CITY OF ALBUQUERQUE

RE: **Juan Tabo Hills Estates**
Revised Grading Plan
Engineer's Stamp Date: 7/12/18
Hydrology File- M21D018; DRB# 1005278

Based on the submittal received on 7/20/18, the revised grading plan cannot be approved until the following are corrected:

GRADING NOTES:

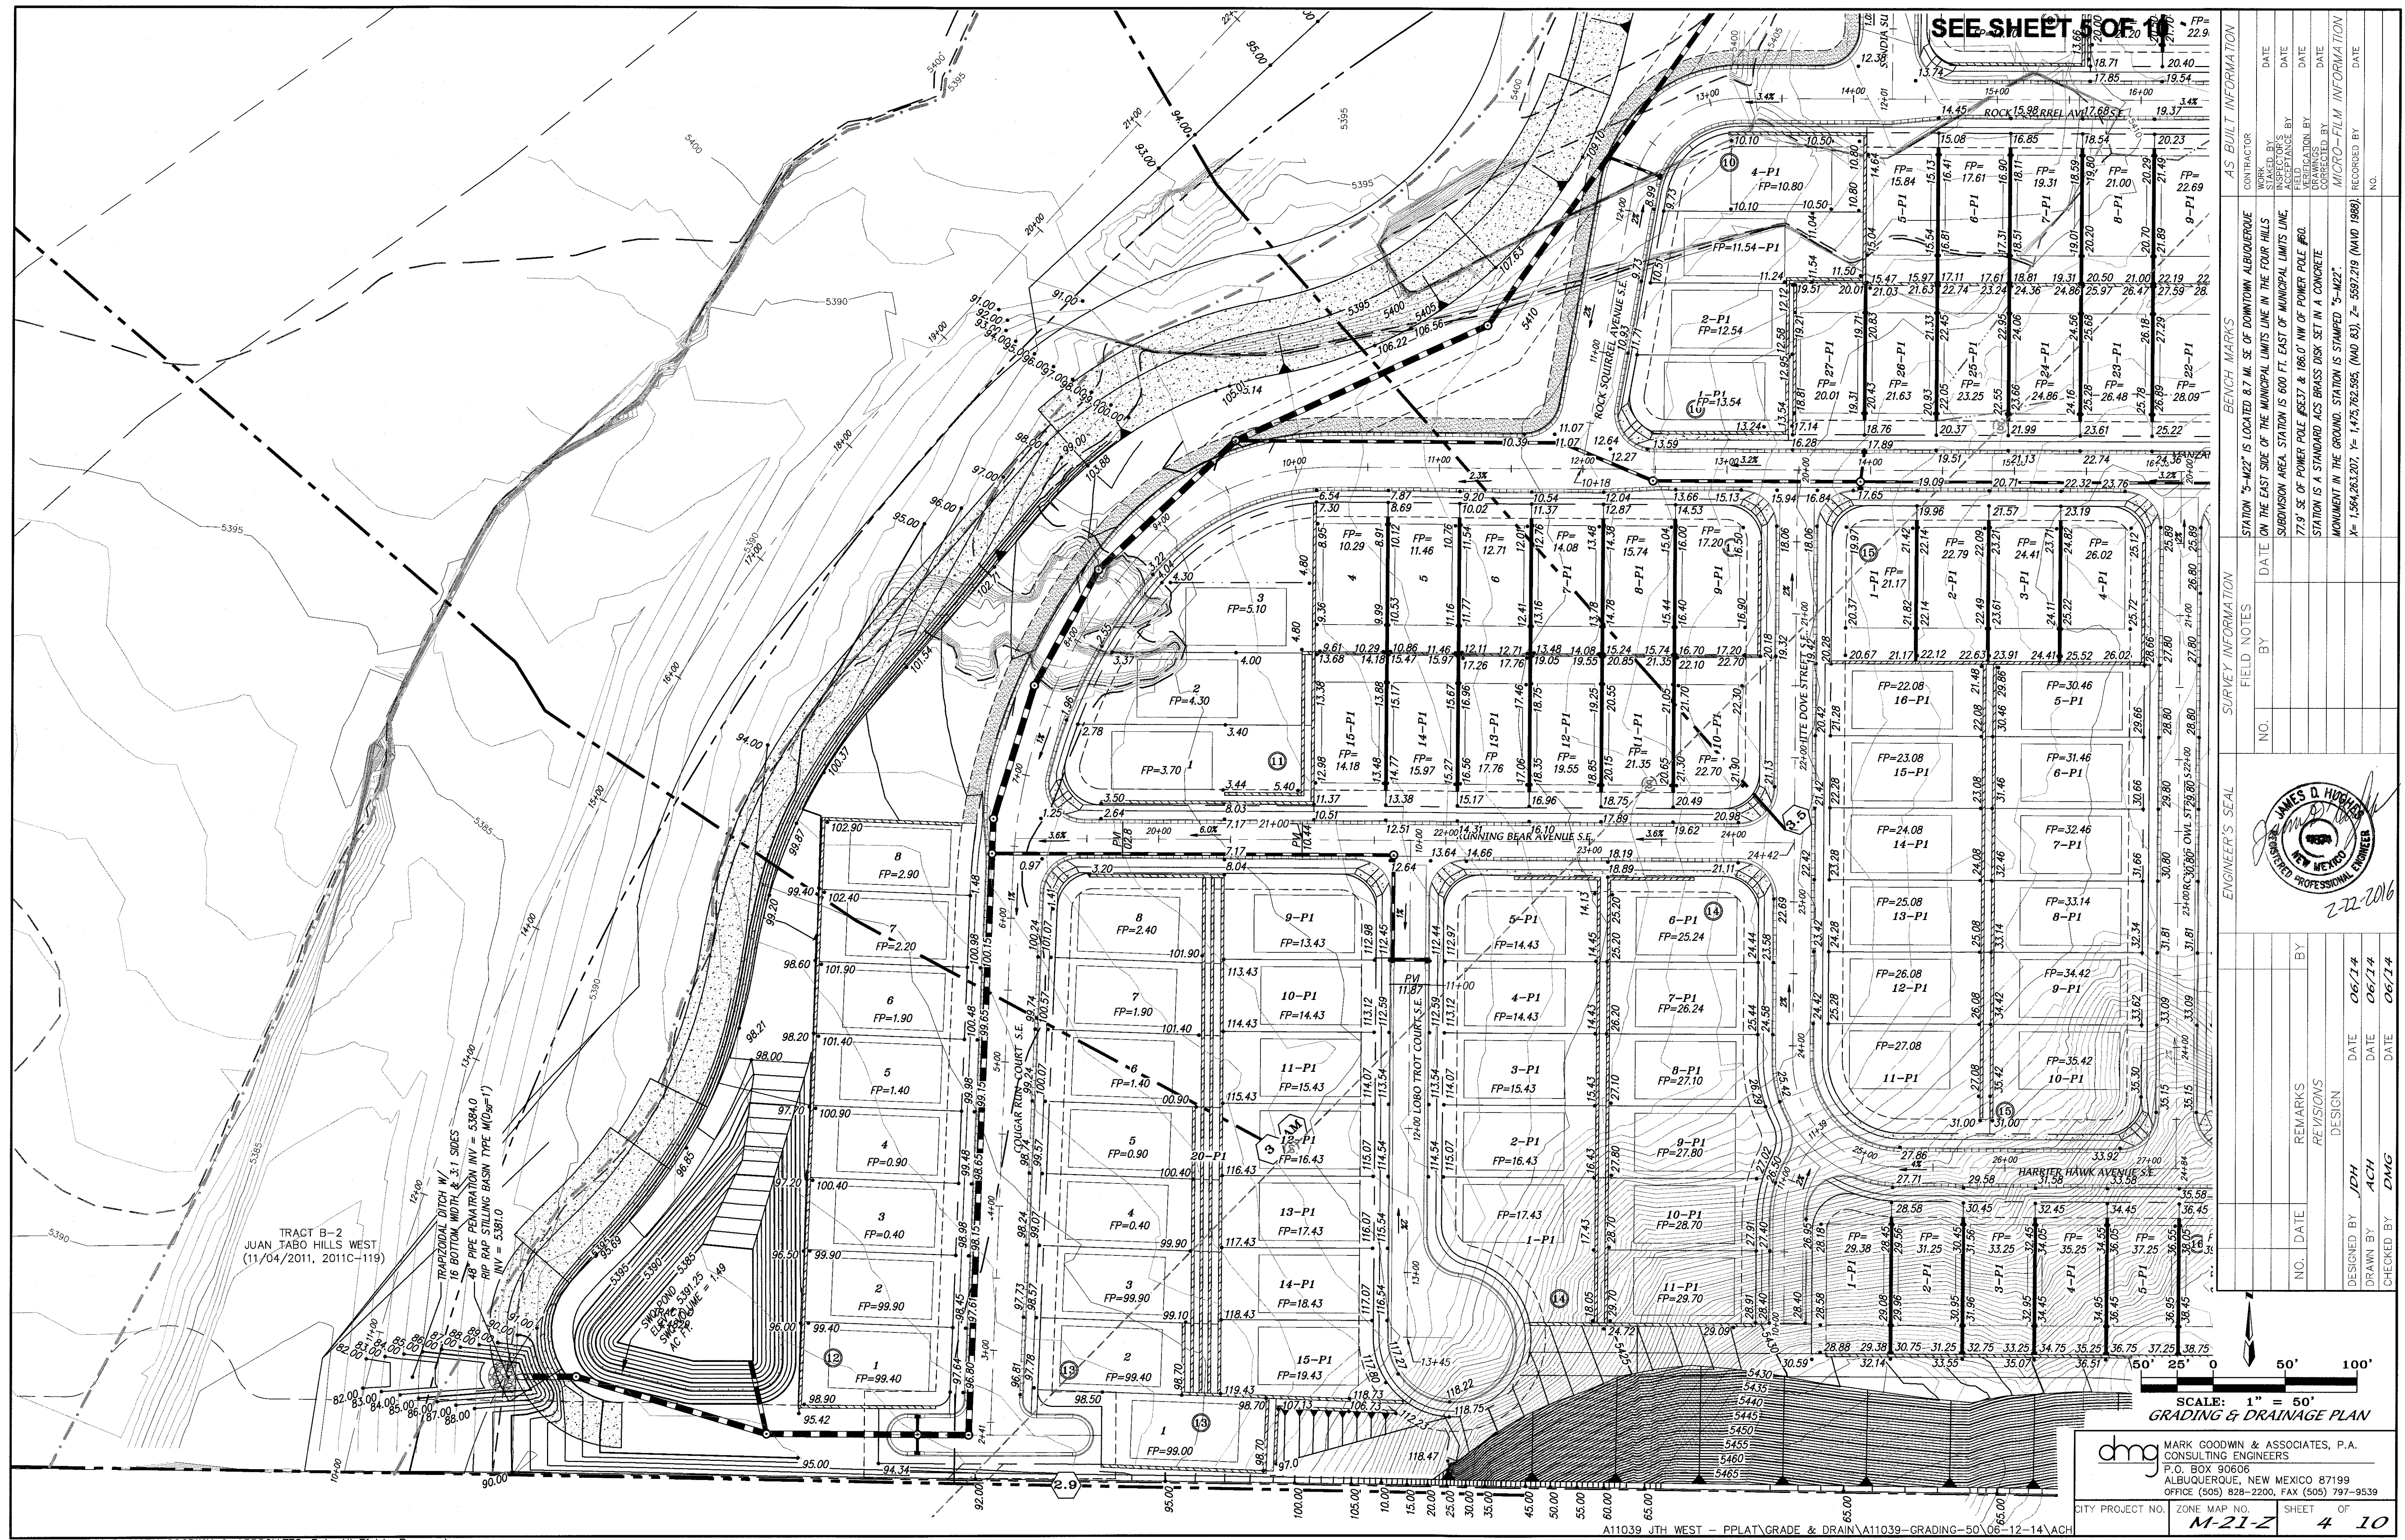
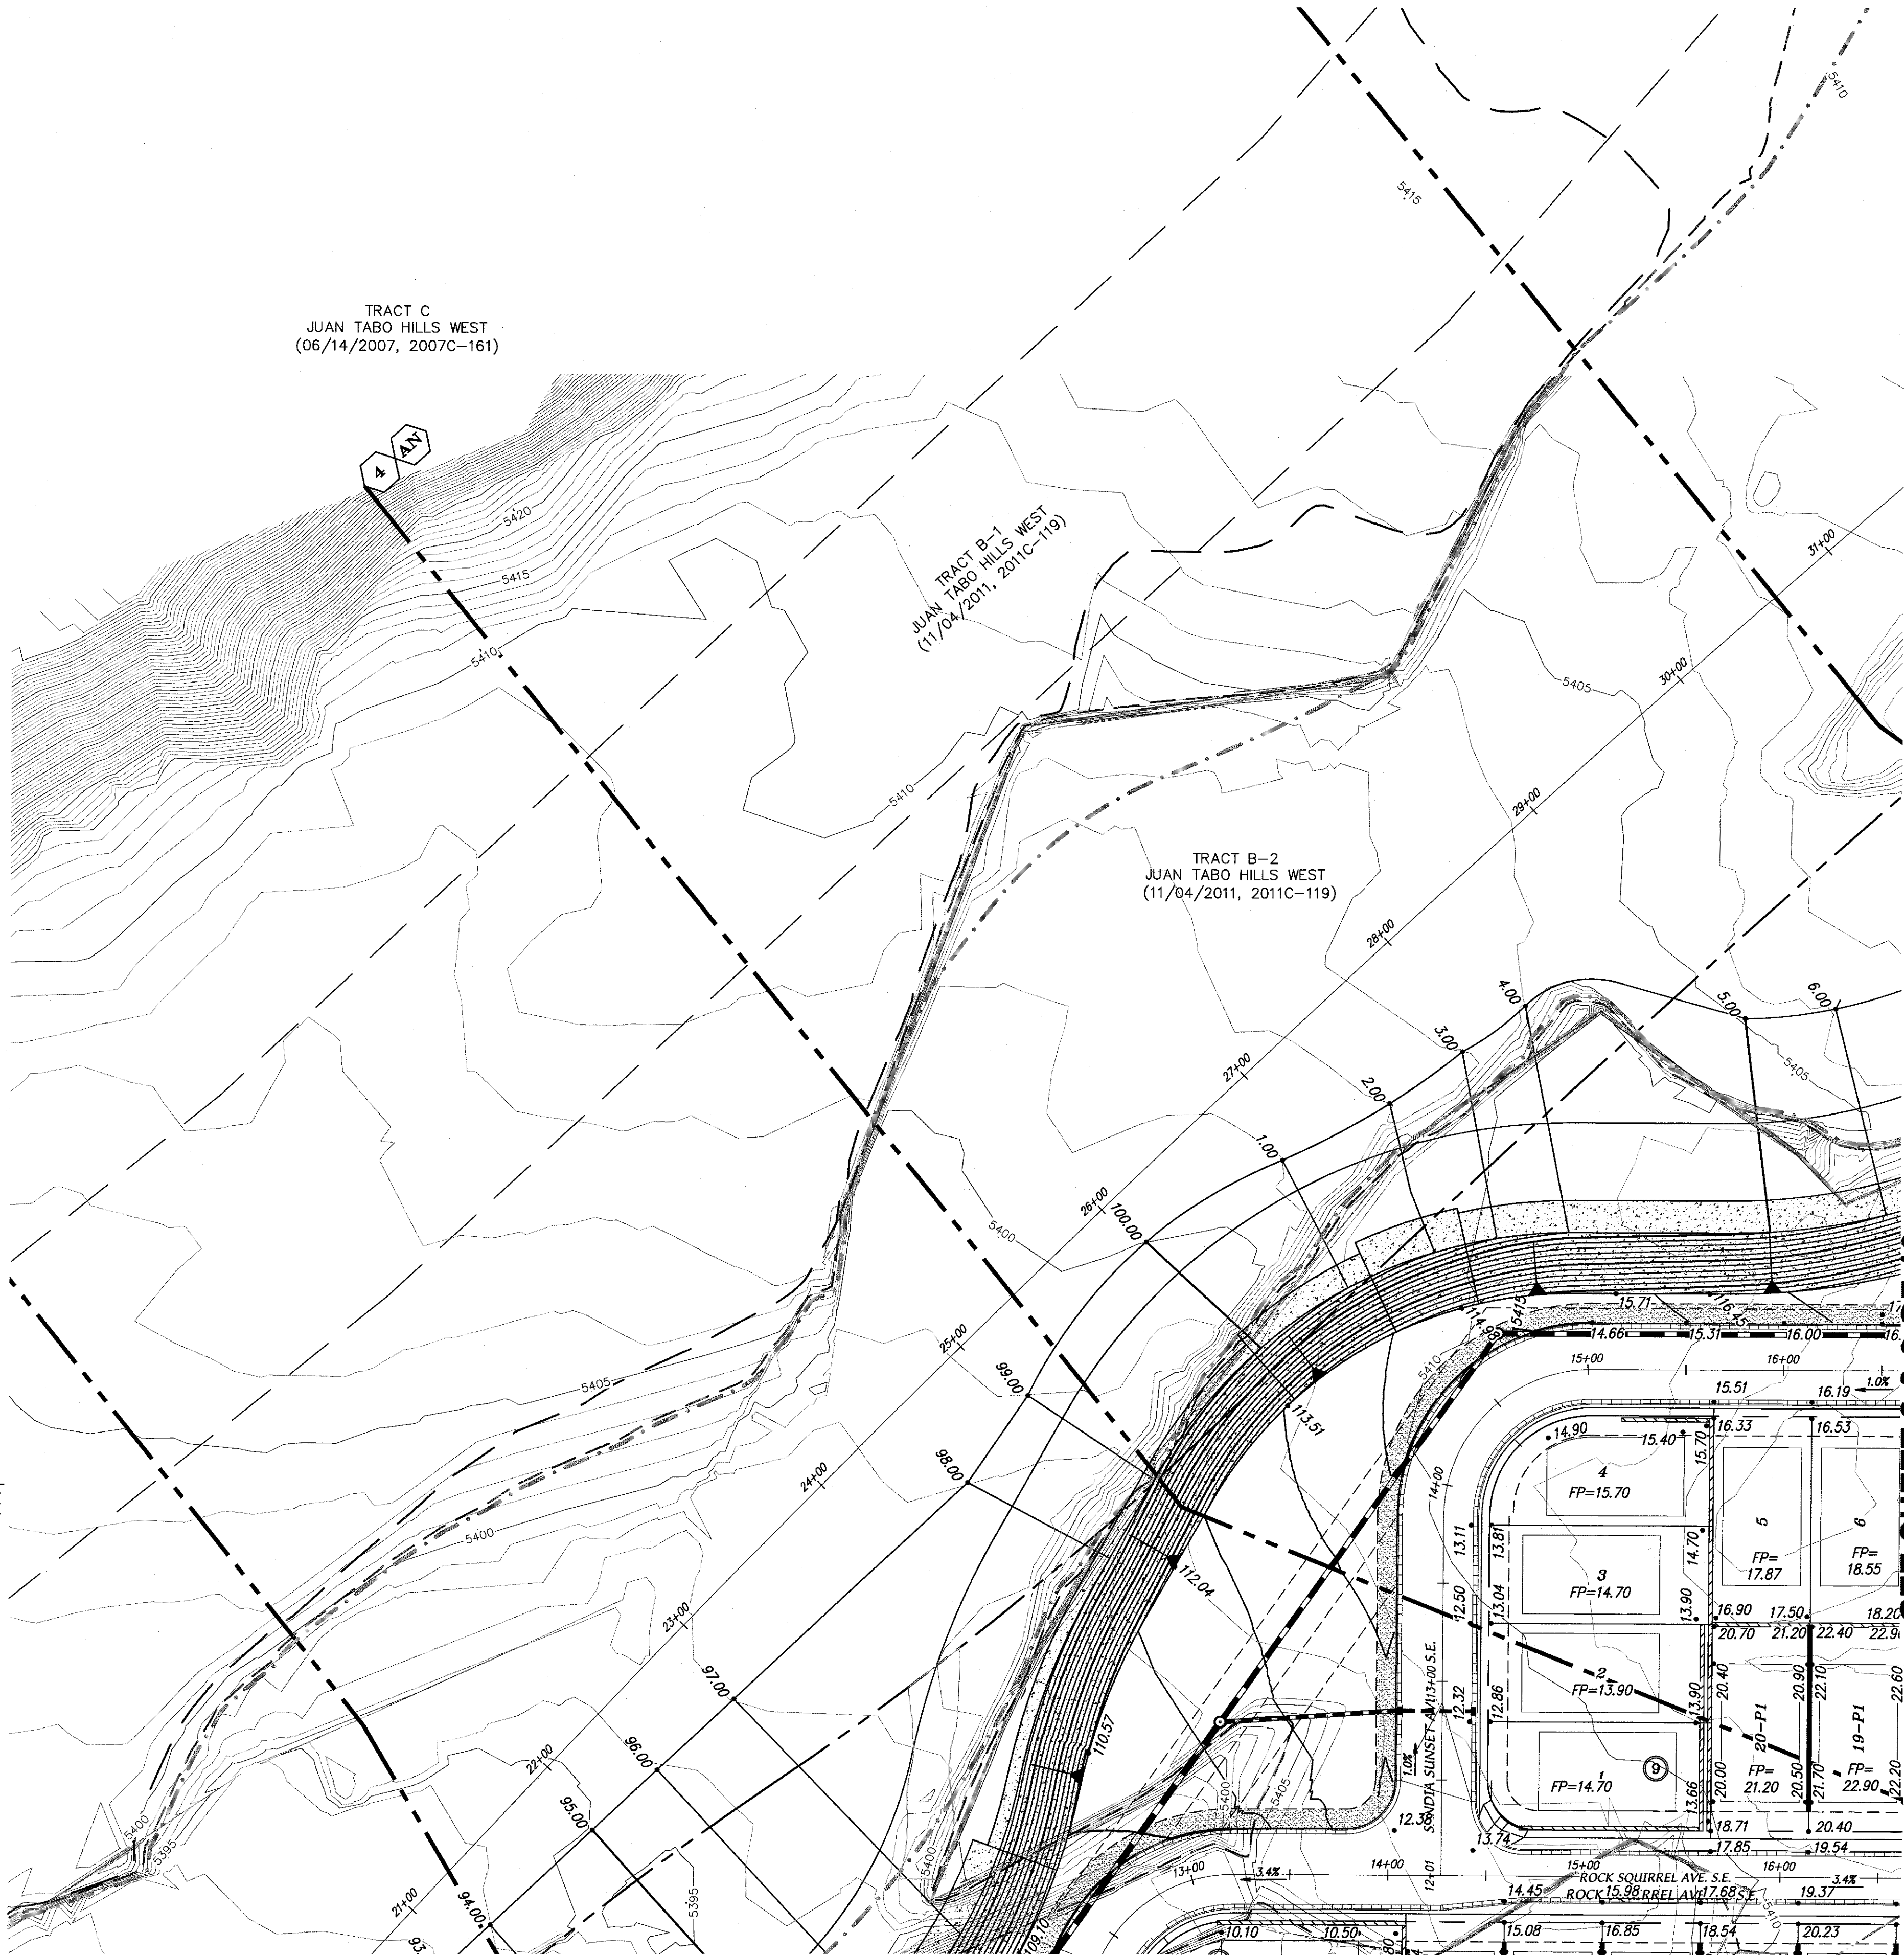
1. Fill in or provide an armored drainage conveyance for the low spot south of the Rocky Top entrance. This area cannot be allowed to pond adjacent to the road embankment:

2. Provide the sections shown on the grading plan.
3. Provide an armored drainage conveyance for the interspaces between the terraced retaining walls and down into the storm water pond; ensure the AMAFCA access road is protected from this runoff:

4. Please verify that the AMAFCA maintenance ramp, gate, and retaining walls are consistent with the current bank protection plans:

5. Provide self-ponding areas in the interspace (park) between the AMAFCA access road and the public road. The contours and spot elevations should reflect the access road as sloping at 2% away from the top of shotcrete and back into the park area. The ponding areas should be sized for the 10-day, 100-yr volume with supporting calculations provided.
6. This plan proposes lot adjustments and changes to the approved grades in excess of 18" and within 50' of the property line (vicinity Lot16, Block13). The amended preliminary plat will require Development Review Board approval (Hydrology approval of the revised grading plan will be a pre-requisite of the amended plat):

7. Many of the Lots have been re-numbered. Is this intentional? This will need to be updated on the amended preliminary plat as well. Look at: Block 19, Block 14, Block 13,
8. Lot 8(?) of Block 12 is not labeled. Lot 6(?) of Block 4 is not labeled. Lot 6(?) and Lot 7(?) of Block 2 are not labeled.
9. The pads for: Lot 1- Block 14, Lot 1- Block 15, Lot 16- Block 9, encroach into the ROW; please correct.
10. Explain the switch to the dual pipe penetration at the SW pond. Is this reflected in the bank protection plans? Where are its build notes? It is still labeled as a single 48" pipe. The grading for the AMAFCA access ramp should be shown here as well as the grades for the emergency spillway:

11. Will this pond still function as a first flush facility? If not, than payment of the Fee-in-Lieu will be required at a rate or \$6/cf for the SWQ volume.
12. Provide rip-rap armoring at the outside bend of Sandia Sunset. If water surcharges out of the NMDOT inlet upstream near MH-47, flows will travel overland down Sandia Sunset and will likely jump the curb at this bend:

13. Hydrology recommends putting the prudent line for the Tijeras Arroyo on this grading plan if desiring to obtain Pad Certifications prior to acceptance of the bank protection. Otherwise the prudent line will need to be added on each Pad Certification.
